**RESPONSE TO SUBMISSIONS  
7 RAILWAY STREET, CHATSWOOD**

We write to you on behalf of Mirvac Projects Pty Ltd and thank you for the opportunity to respond to the submissions that were received in the relation to section 75W modification application (MP09-0154 Mod 1).

8.8m MEDIUM RIGID VEHICLE
 SWEEP PATHS

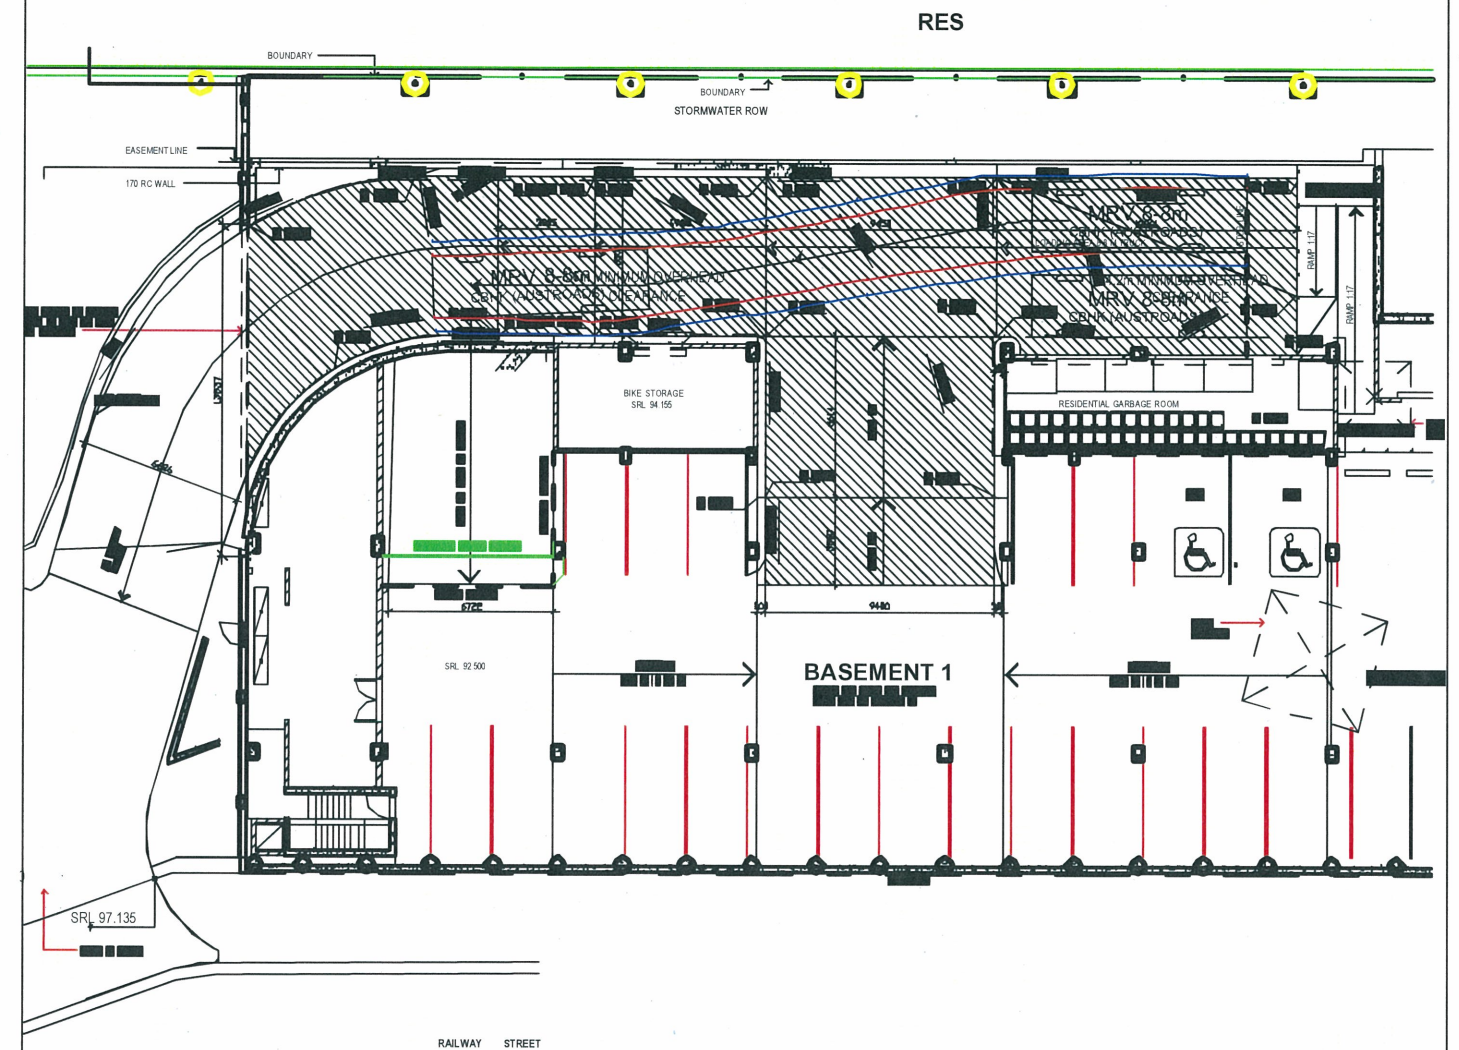
The RMS does however have concern in relation to the proposed amendment to condition B2(g) and the potential for vehicular conflict between reversing trucks exiting the loading dock and vehicular movements. The RMS does not consider that *‘the proponent has demonstrated how they intend to address this deficiency, and what measures will be put in place to ensure that access/safety to the car parking access area is not compromised’*.

A loading dock management plan is to be prepared which will ensure the safety movement of service vehicles within the basement. CBHK will prepare the management plan in association with Parking and Traffic Consultants Pty Ltd who will advise on measures to manage service vehicle activity.

The loading dock management plan will incorporate signs and warning lights (traffic light system) within the access driveway and basement car park, informing motorists when service vehicles are accessing or existing the loading dock.

At all times passing opportunities will be provided within the access driveway at Railway Street and within the basement car park, with clear sight lines to the traffic light system. The traffic light system will incorporate height beams at the access driveway and within the loading dock, which will be activated by service trucks when entering the site and exiting the loading dock.

- all vehicles entering and exiting the site will be required to enter and exit the site in a forward direction;
- service vehicle access to the site will be controlled by signs and warning lights (traffic light system) located within the access driveway and within the basement car park;

- hold bays and passing opportunities will be located within the access driveway and within the basement car park;
- the traffic light system will incorporate height beams at the access driveway and within the loading dock, which will be activated by service trucks when entering the site and exiting the loading dock;

- on entry to the service vehicle area, service vehicles will drive in a forward direction into the car park ramp and then reverse into the available loading bay;

- the access ramp to the basement car park has been designed with a maximum grade of 1 in 16 to allow service vehicle access;
- on exit, service vehicles will activate the traffic light system and drive out of the loading dock in a forward direction via the two-way access driveway onto Railway Street;

- when service vehicles are entering or exiting the site the traffic light system will be activated. The signalling system will warn other vehicles entering or exiting the car park to stop within the identified holding areas;

lot no: drawing no: PPR 1008 rev: 5

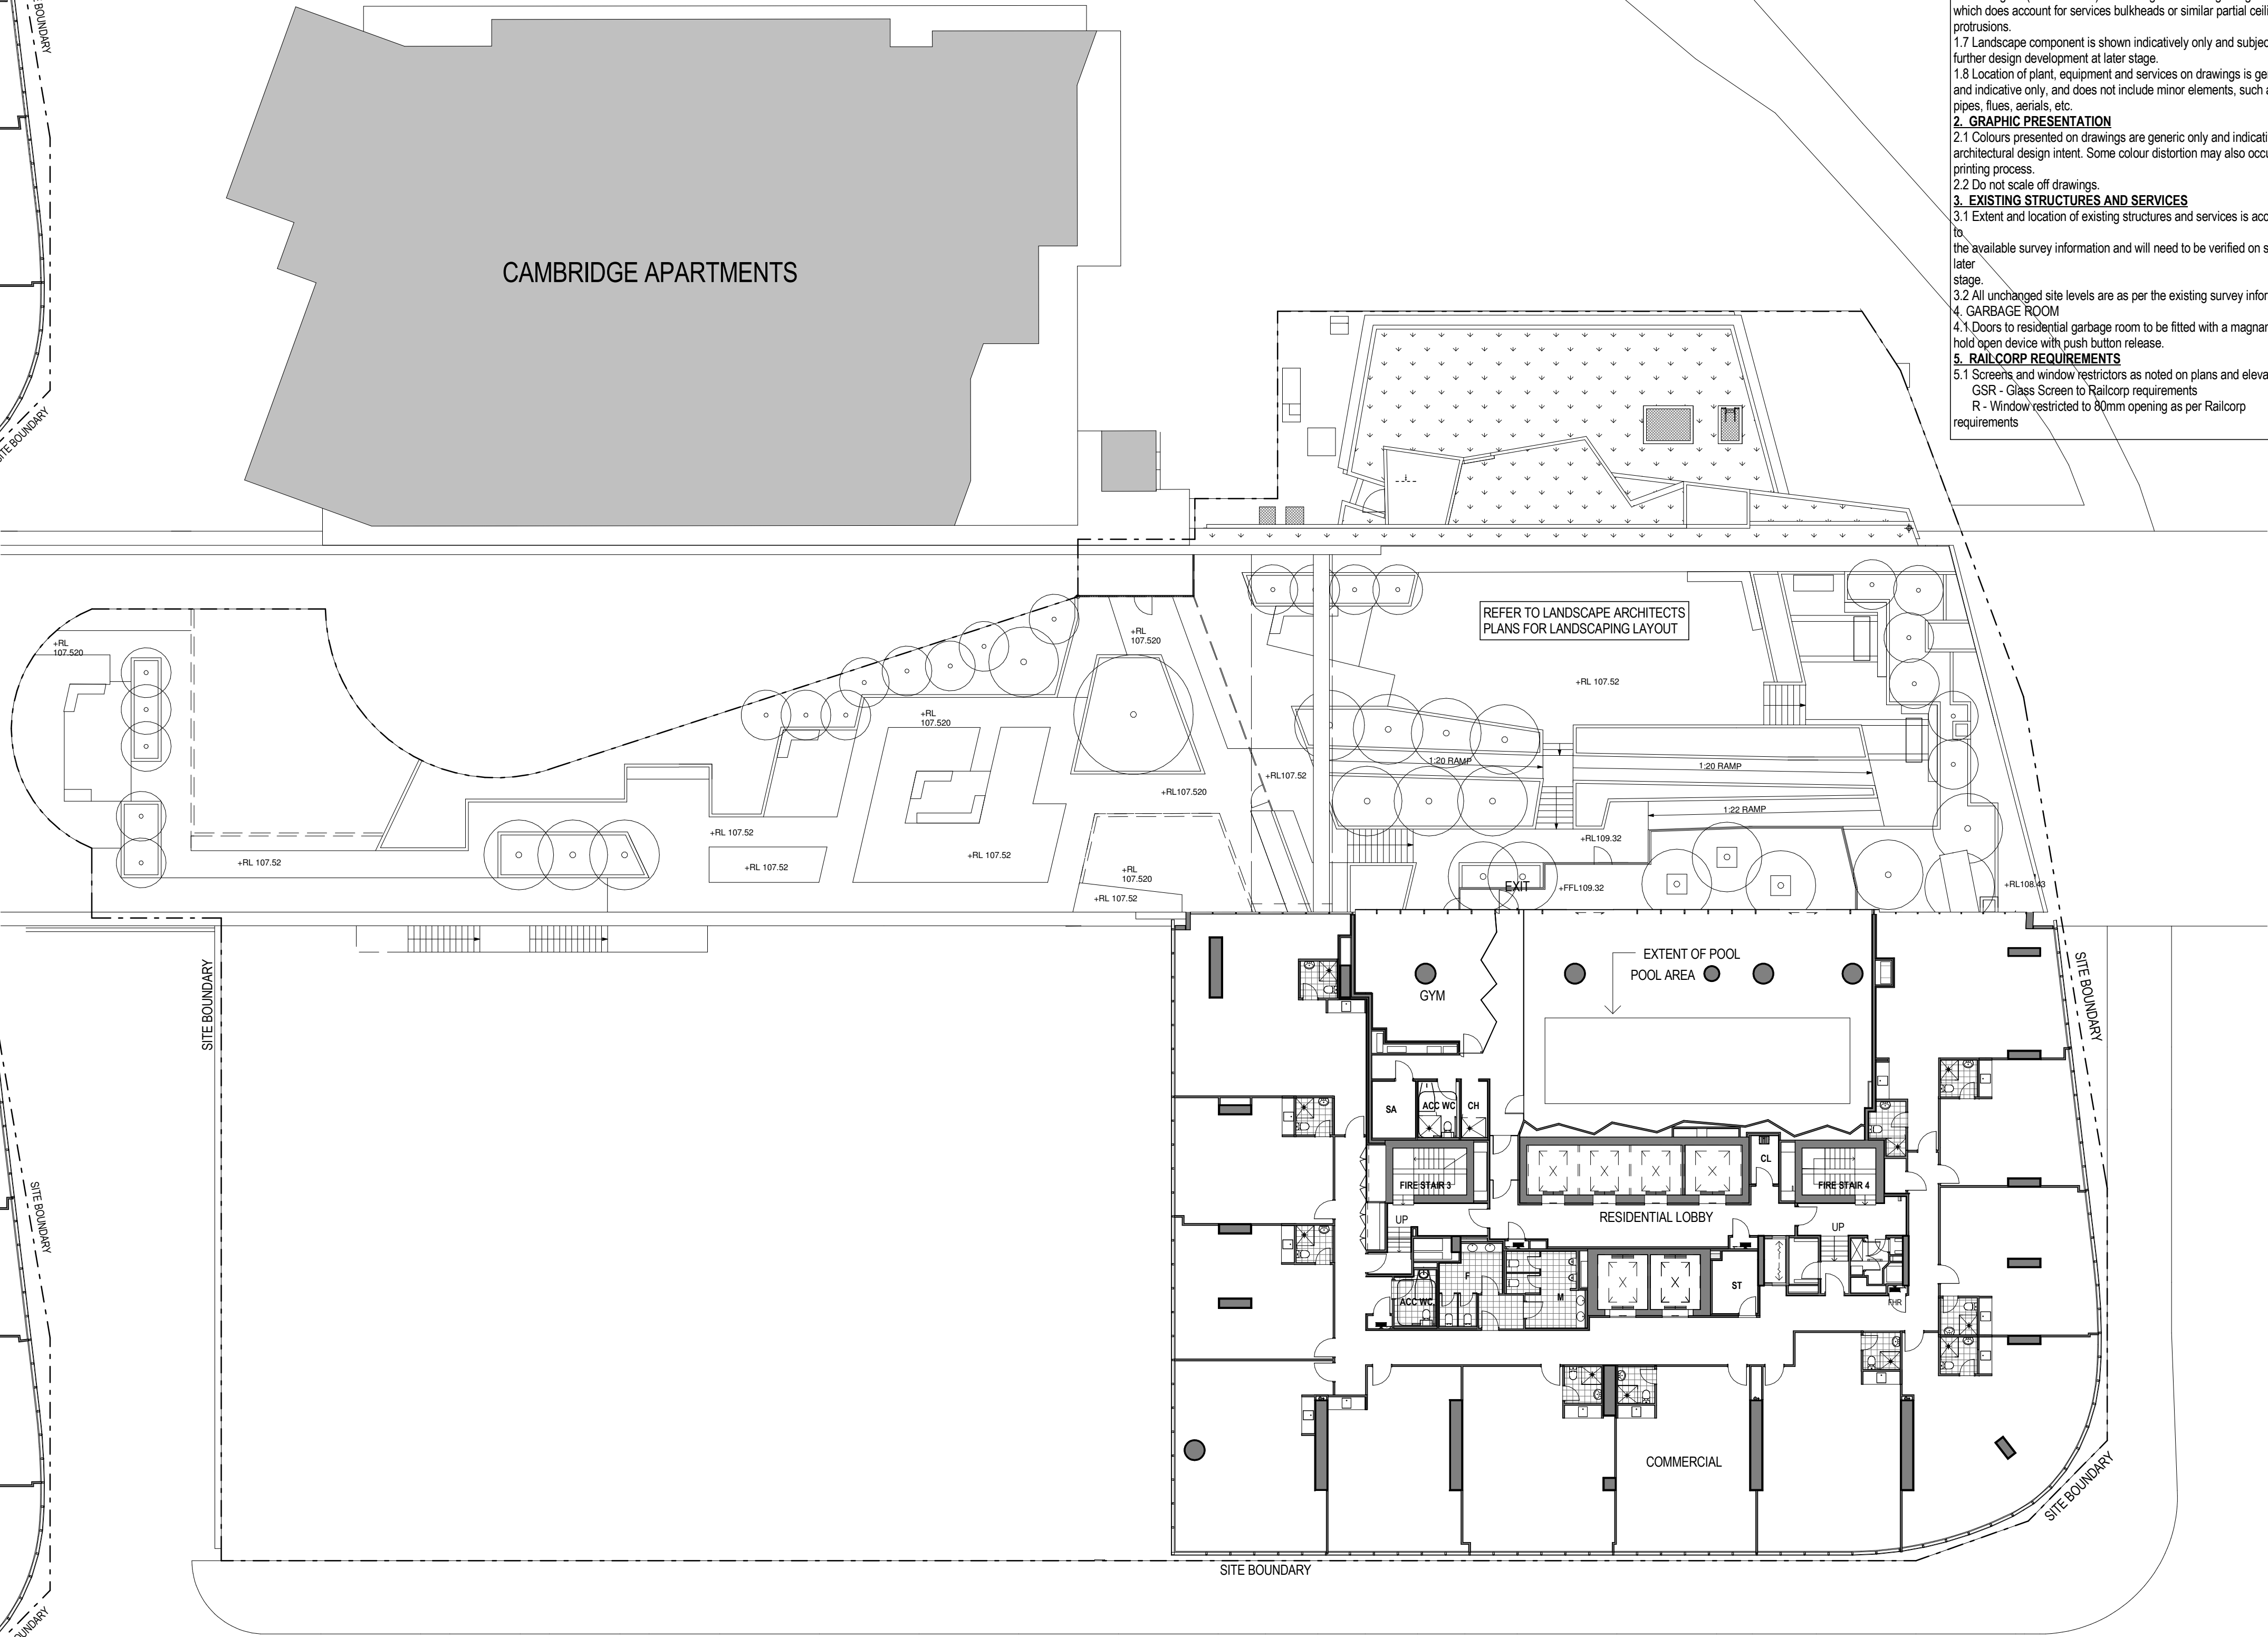
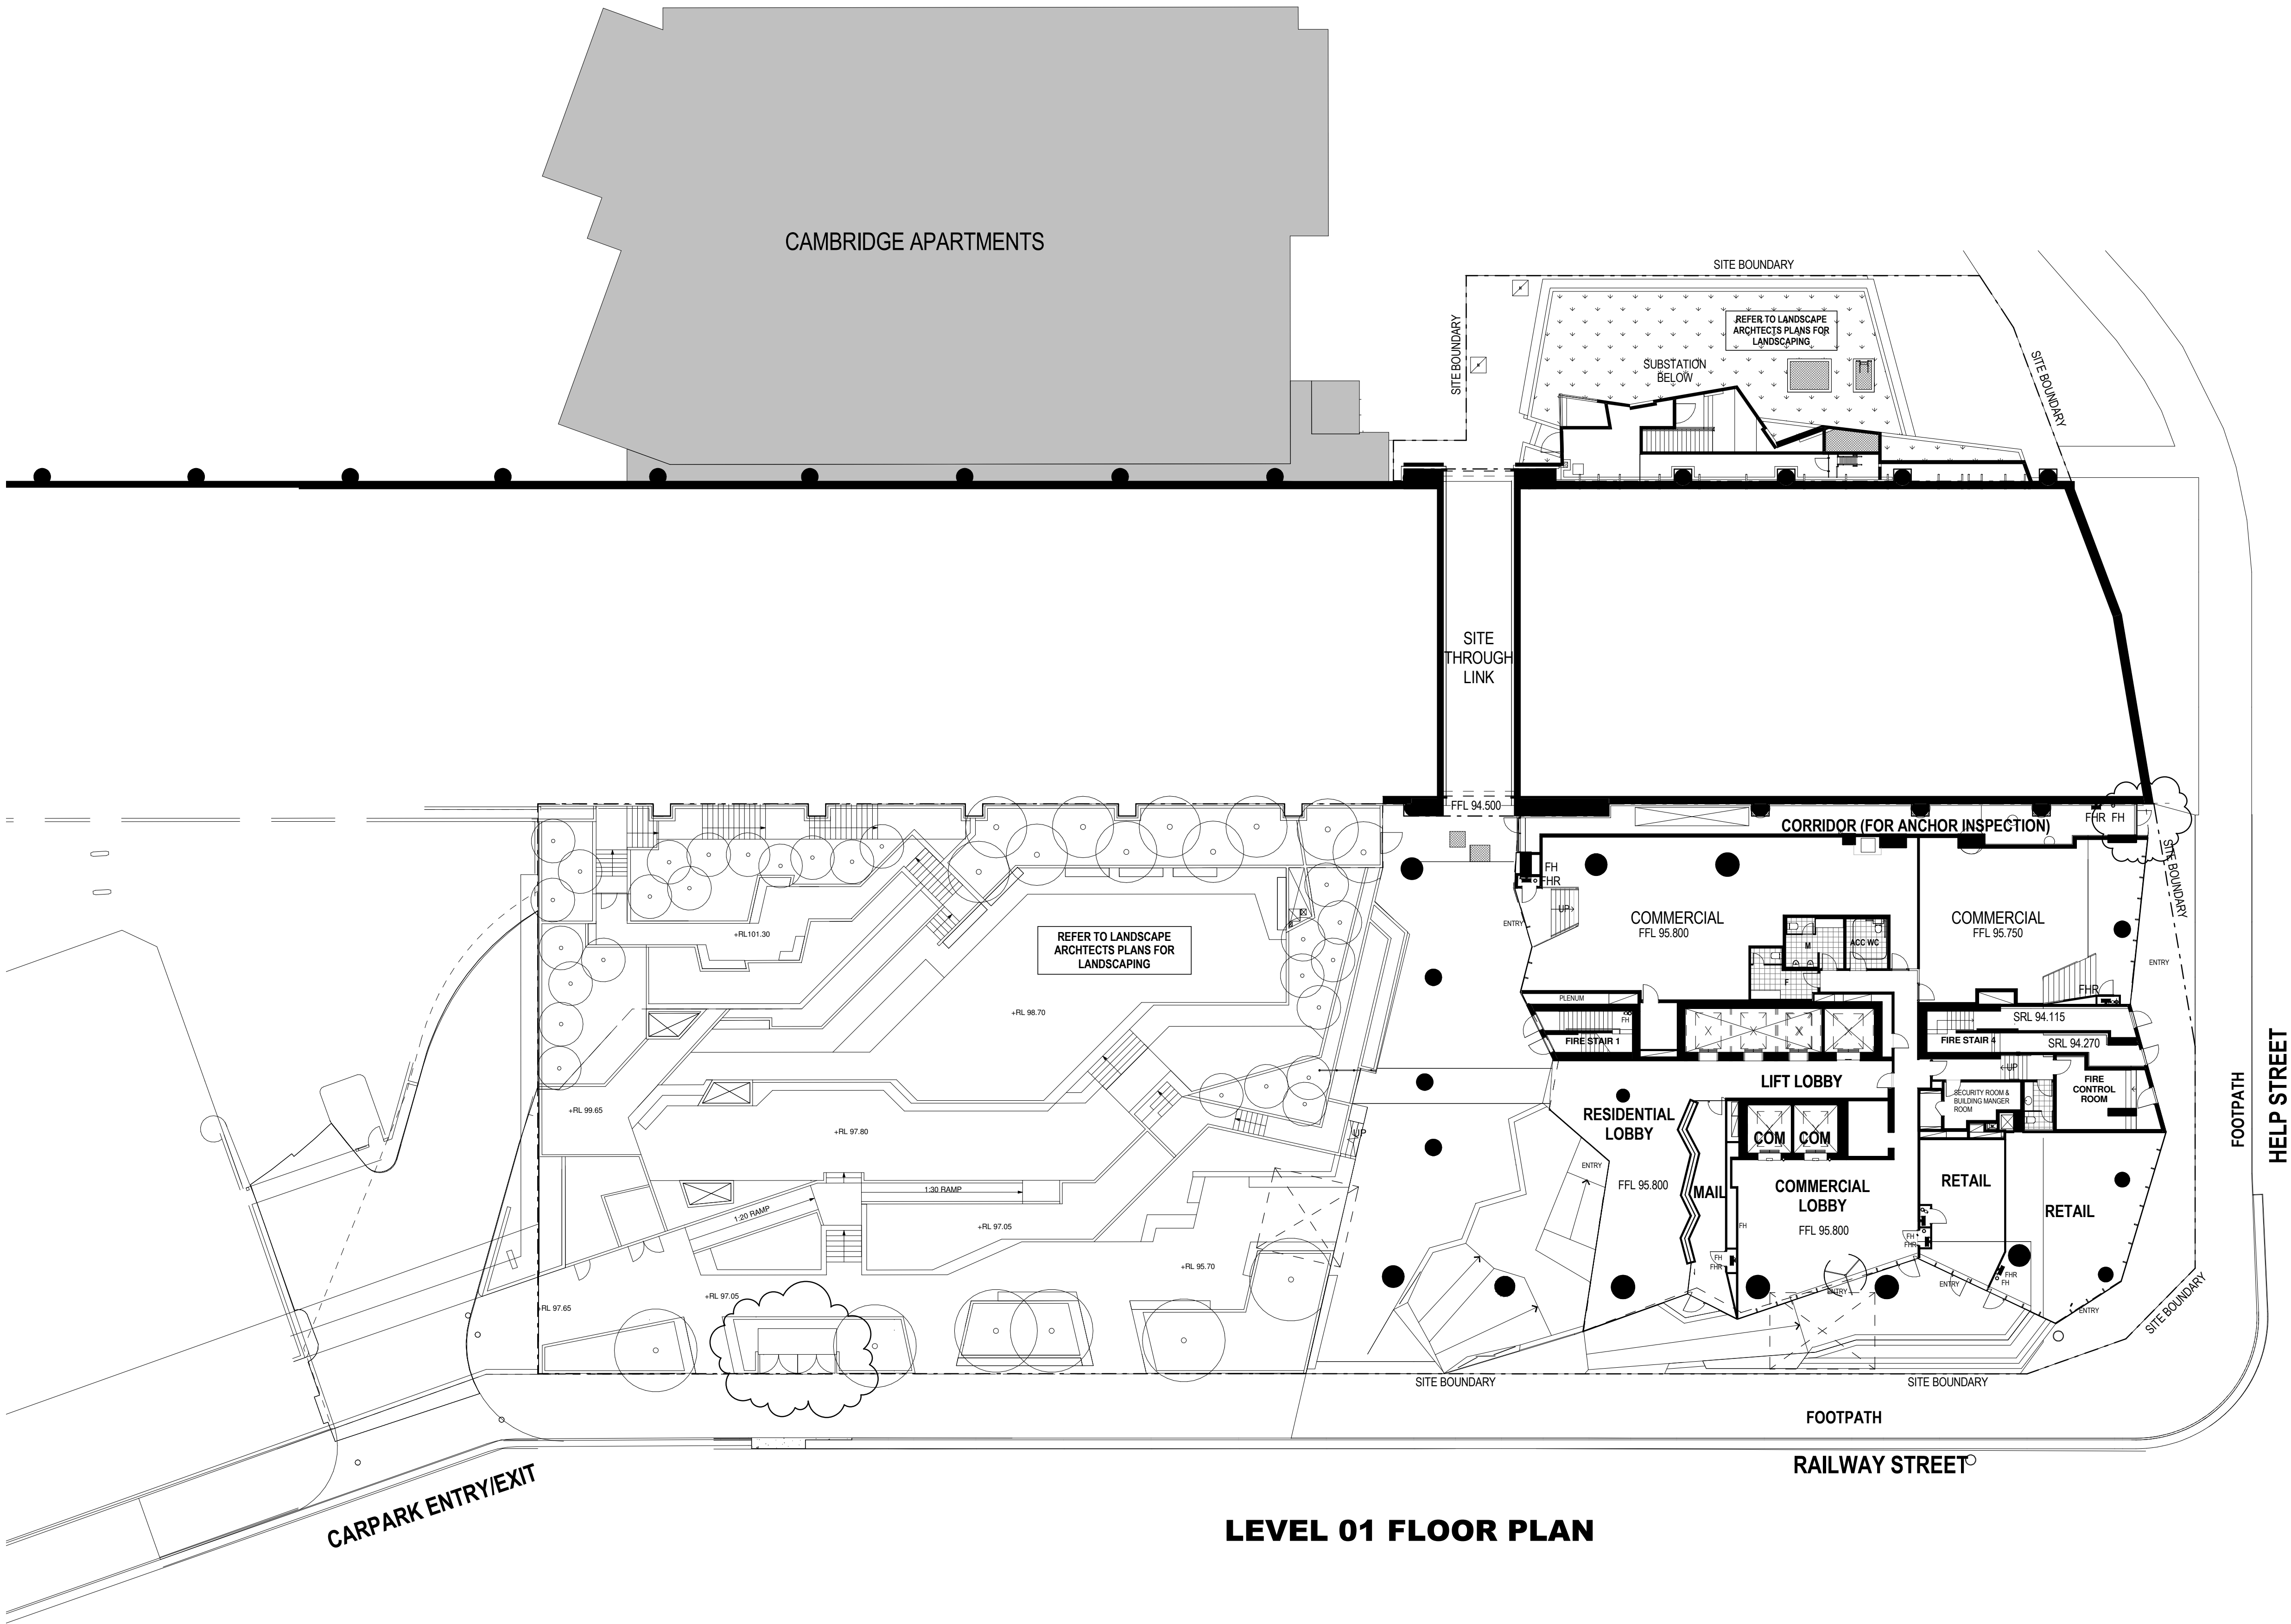
The encroachment on Help Street was a minor drafting error and has now been rectified on the plan PPR 1008 Rev 5 at **Attachment D**.

Council has noted a drafting error on the ground floor plan with regards to the omission of an access door to the commercial tenancy in the south-east corner of the building. The plan has been revised which now shows a door providing access into that tenancy from the main commercial lobby. The door will also ensure that the tenancy has an accessible path of travel and that the occupants of the tenancy will have access to the shared amenities. Refer to drawing PPR 1008 Rev 5 at **Attachment D**.
